Response to Planning Application

From: Arun District Council Greenspace

Application ref: AL/79/20/OUT

Description: Outline planning application with some matters reserved (Layout, Scale, Appearance and Landscaping are to be determined as reserved matters) for the construction of 10 No. dwellings & the creation of a new vehicular & pedestrian access on to Hook Lane. This application is a Departure from the Development Plan.

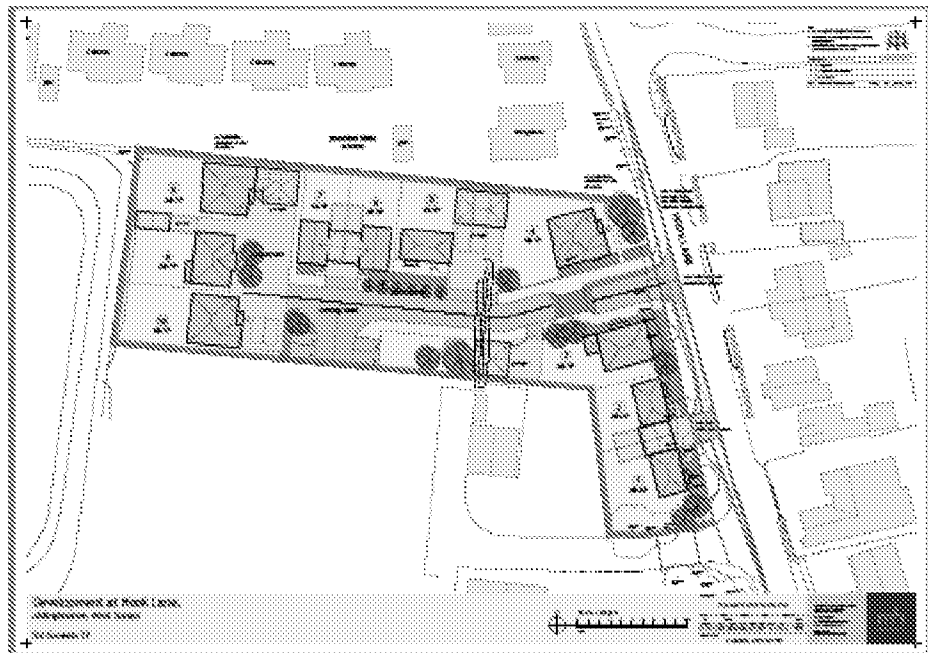
The illustrative Site Plan Dwg No 19-191 HKL MHA 00 XX DR A 0003 Rev P05 shows indicative landscape proposals which would need to be confirmed in plan form to show existing to be retained and new planting detailing species choice, actual quantities, planting densities and size at time of planting.
